# Specific Input from the British Horse Society to A30 Specific Hearing 28 March

## In Relation to Agenda Items:

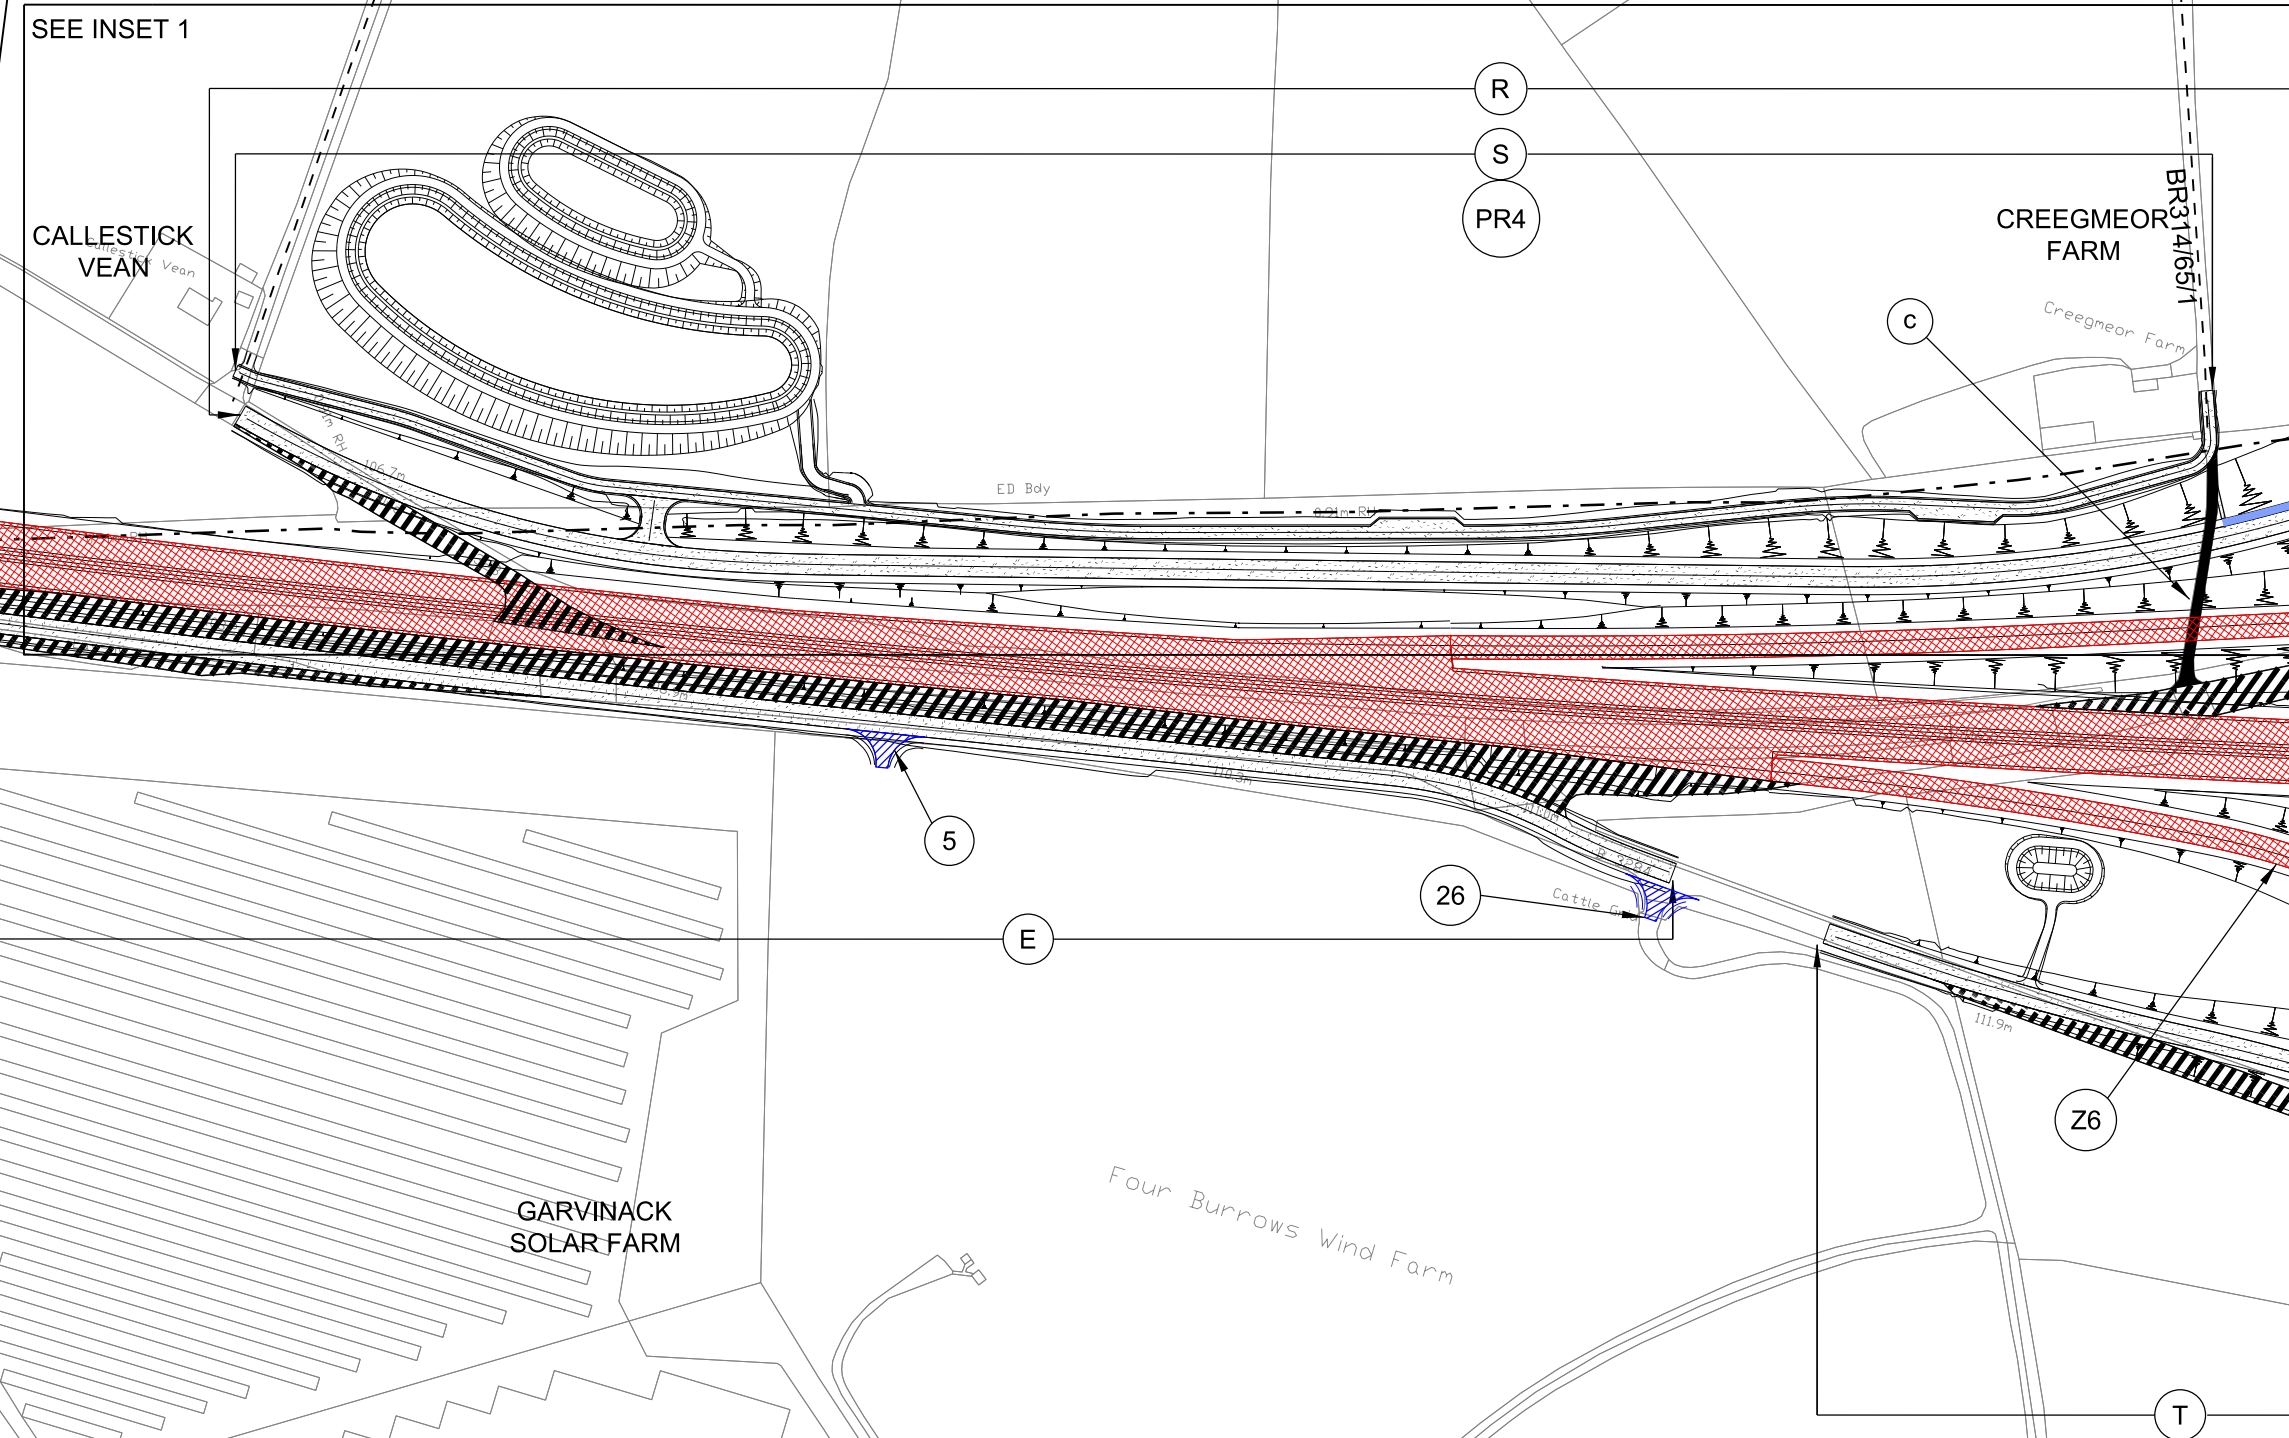
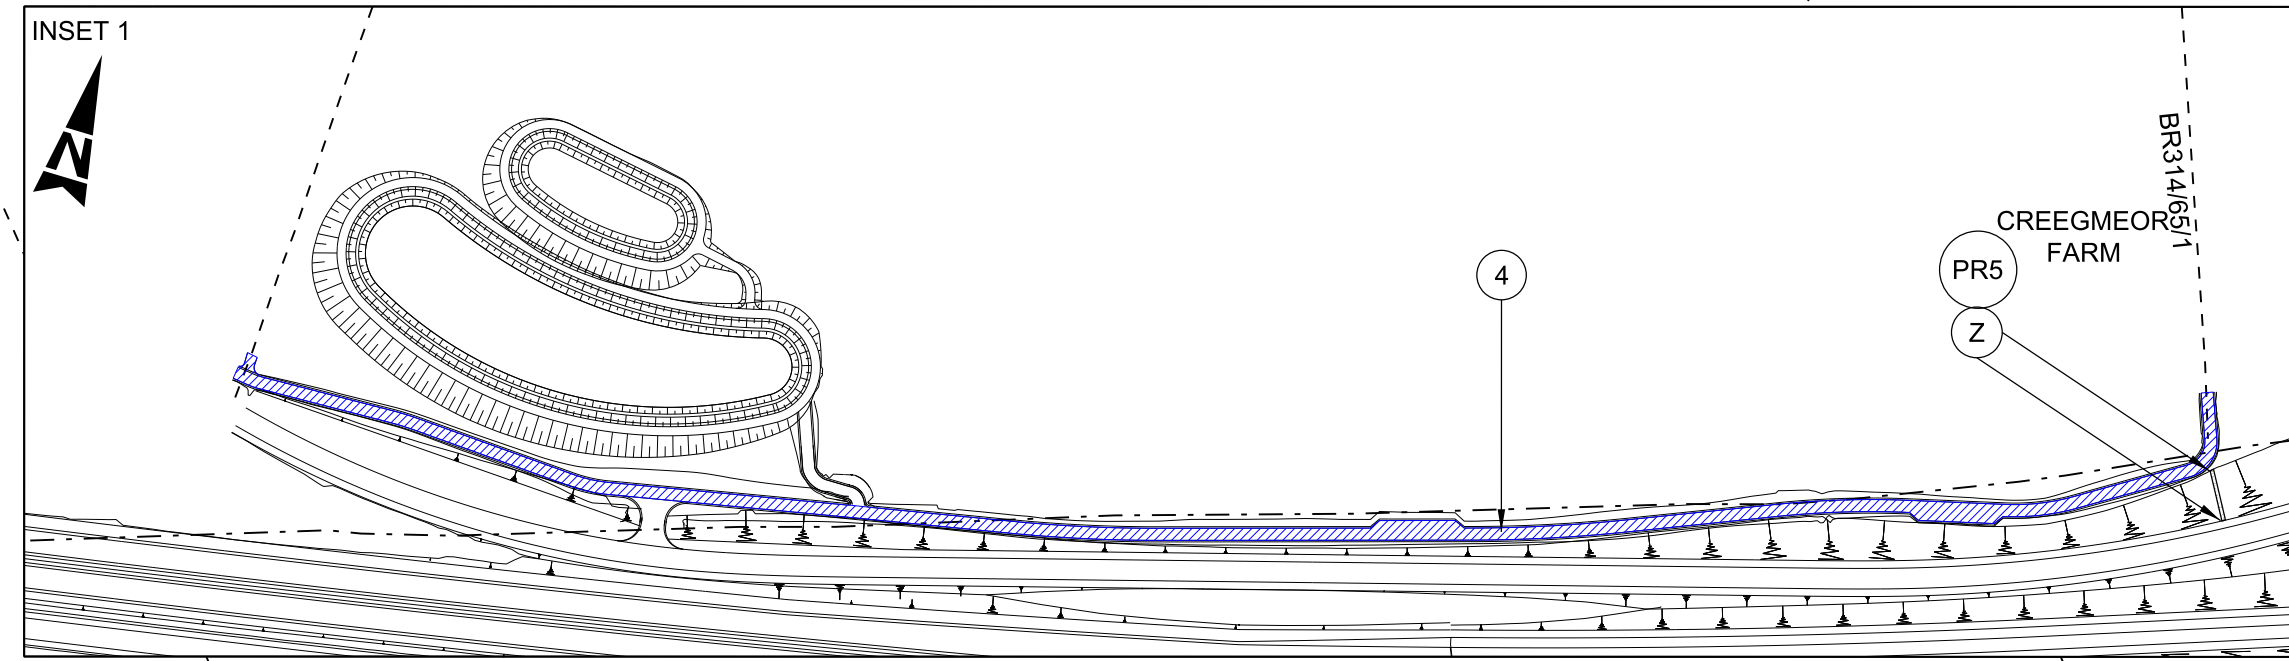
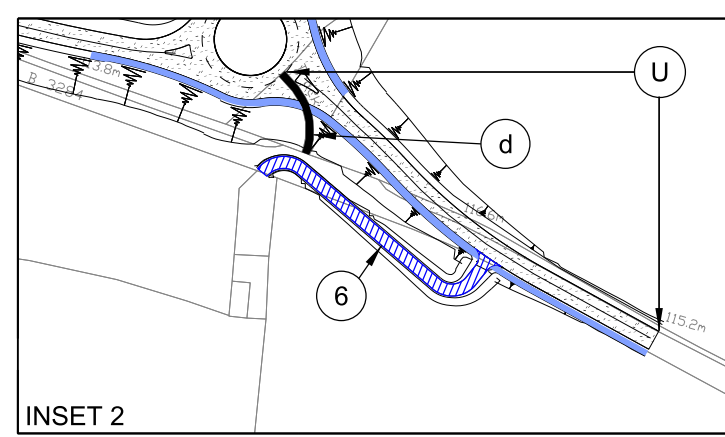
*c. Any matters arising from the CC LIR [REP1-010] comment on Rights of Way and Access Plans Sheet 3-ref. Z (PR5), asking whether this be upgraded to bridleway status rather than footpath.*

- Any additional connectivity inclusive of equines is welcomed and opportunities should not be missed

Drawing Title: **RIGHTS OF WAY AND ACCESS PLANS APFP REGULATIONS 5(2)(K) SHEET 1 OF 8**

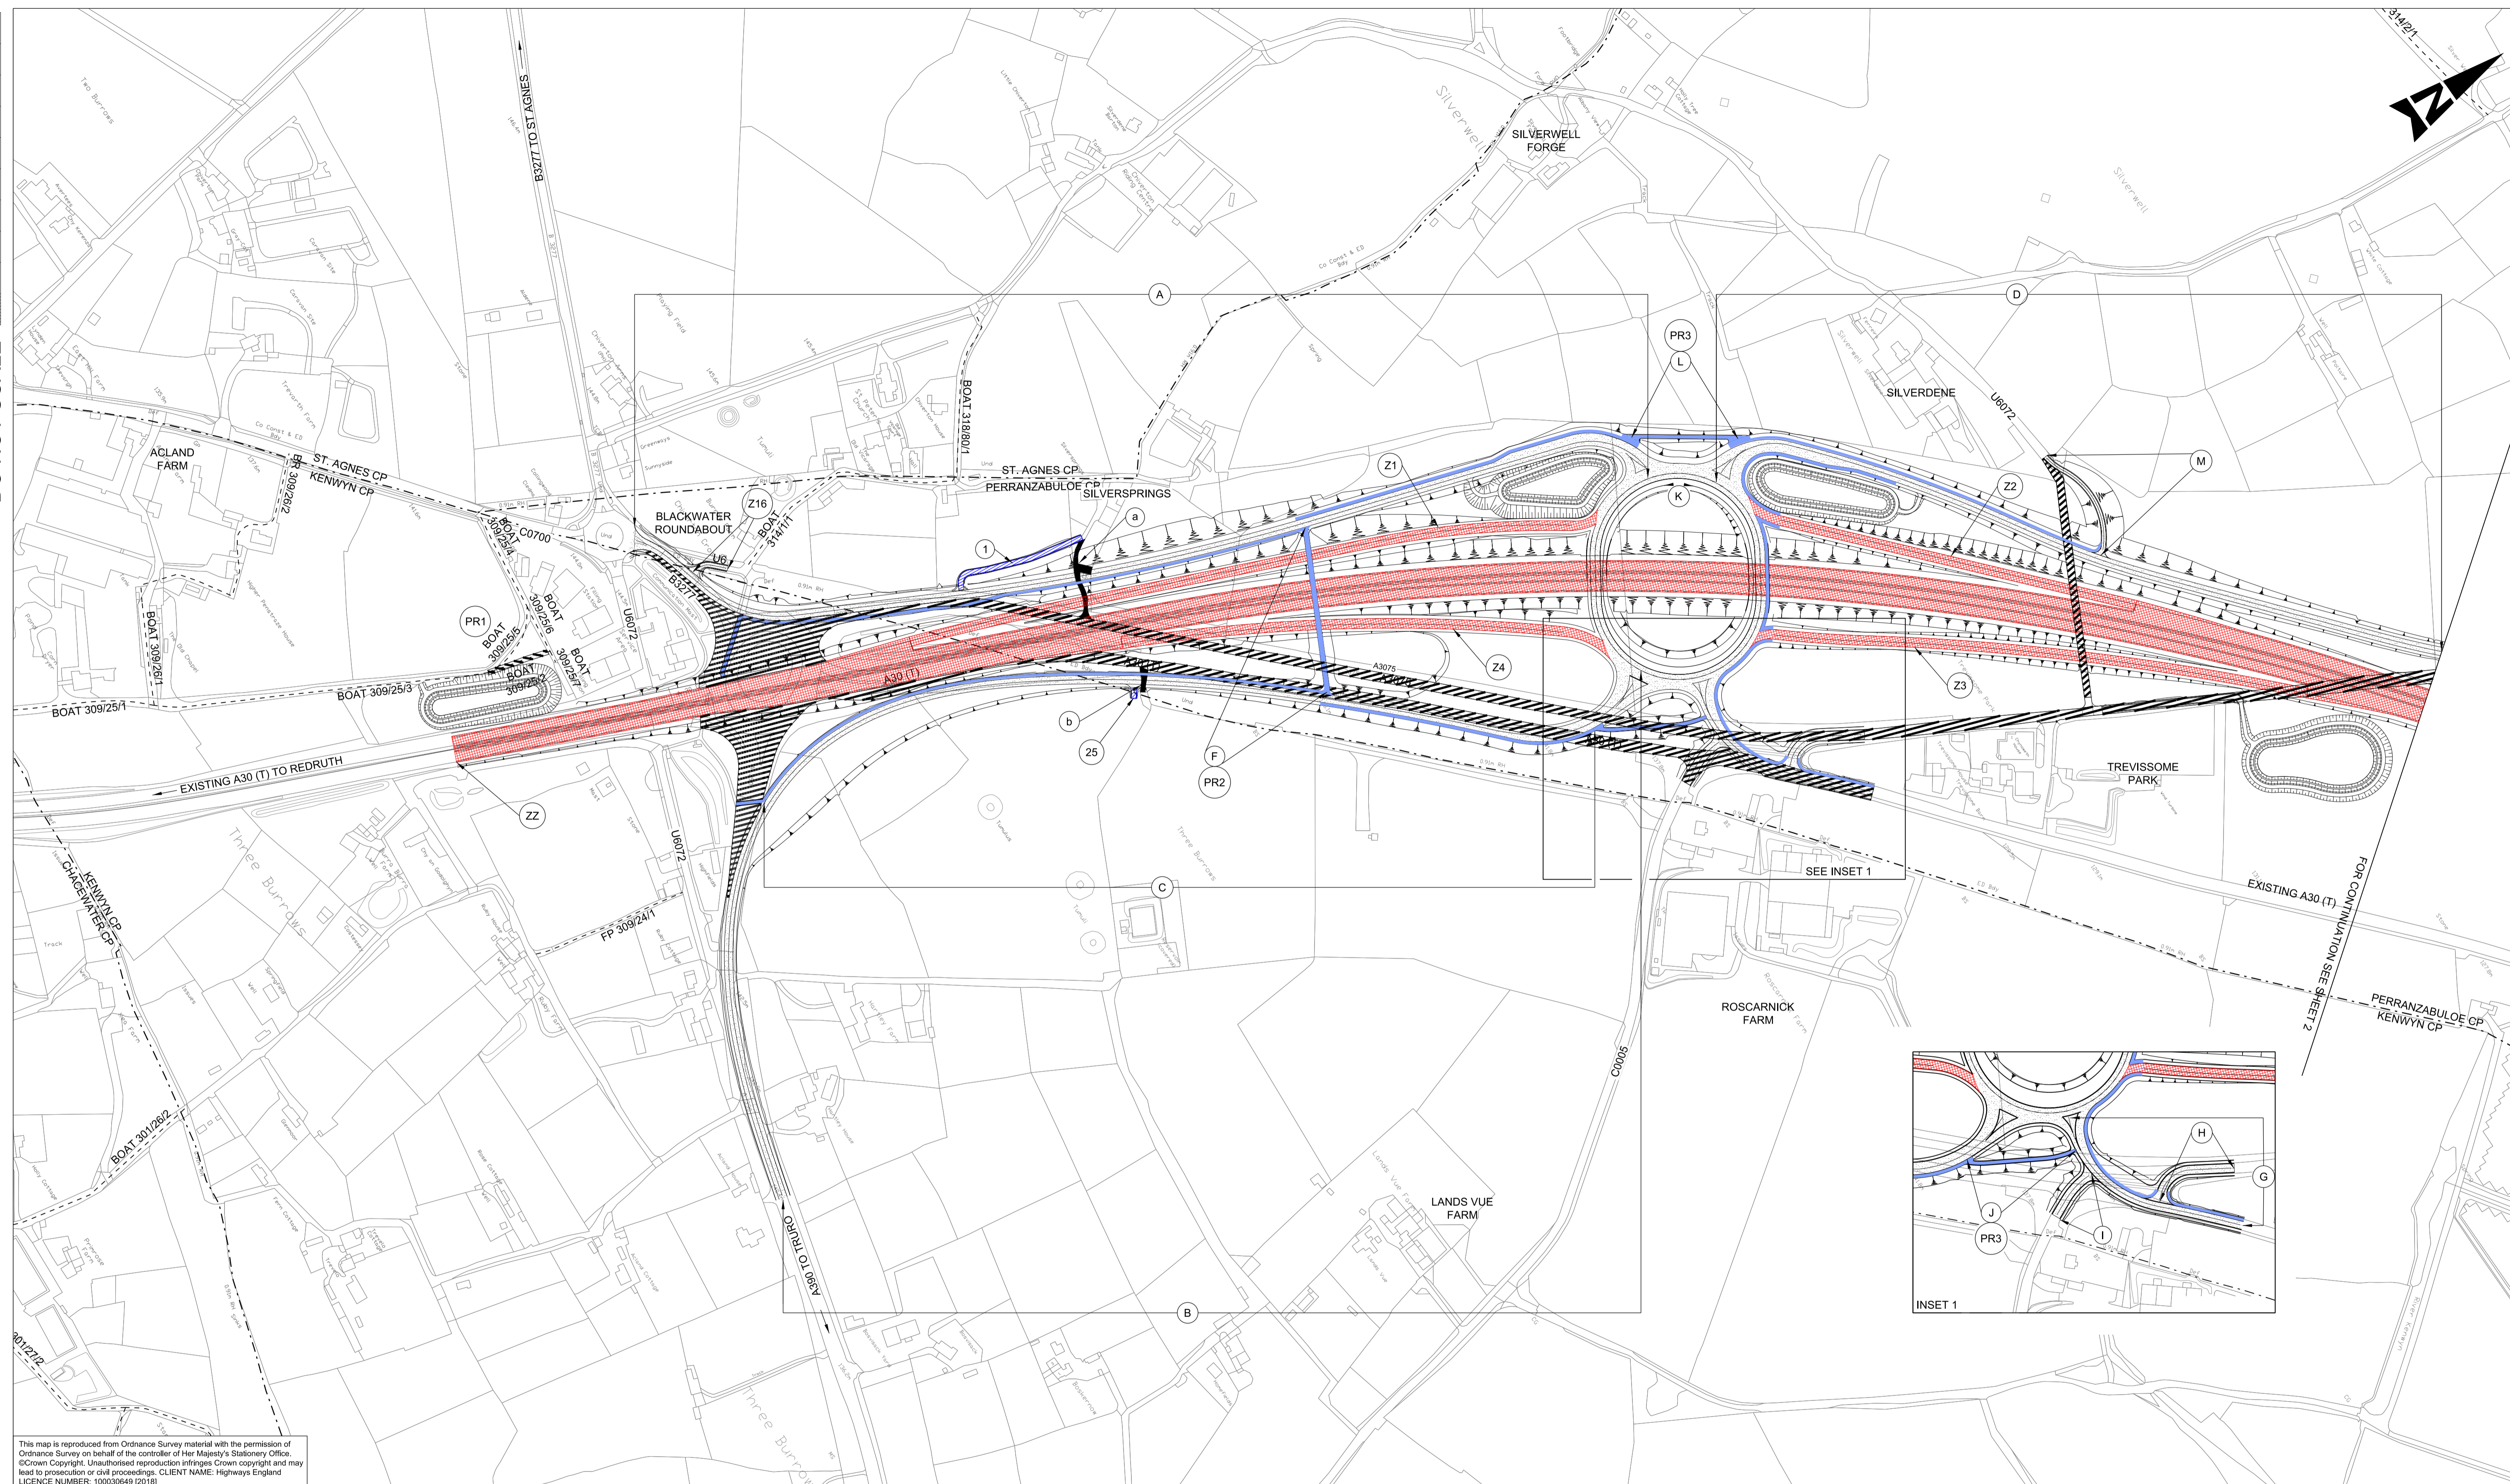
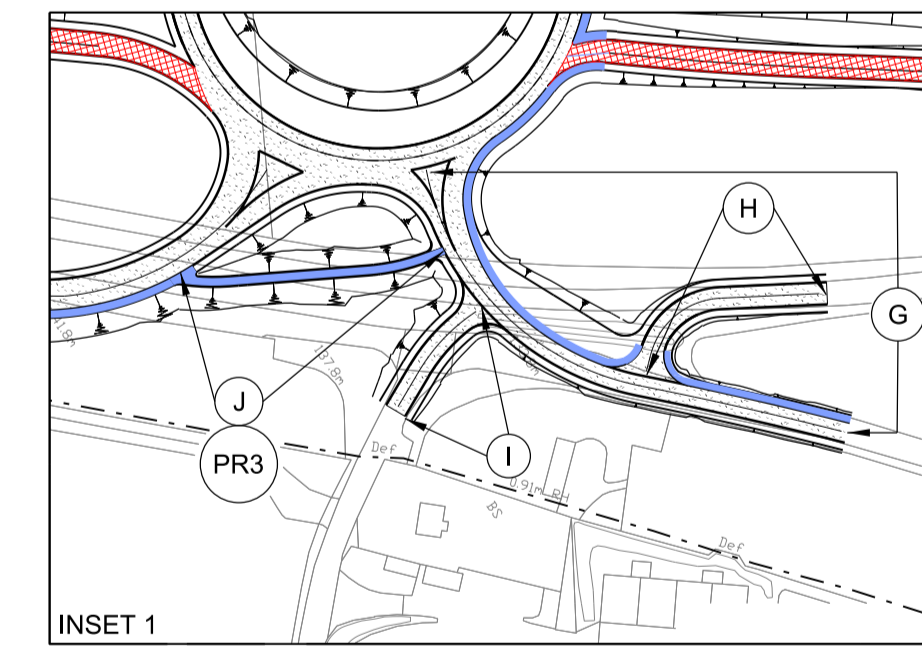
*b. Any matters arising from the CC Local Impact Report (LIR) [REP1-010] comment on Rights of Way and Access Plans Sheet 1-ref. Z11, asking whether there could there be an additional length of path to join BOAT 309/25/7 on the north side of the bypass to increase connectivity.*
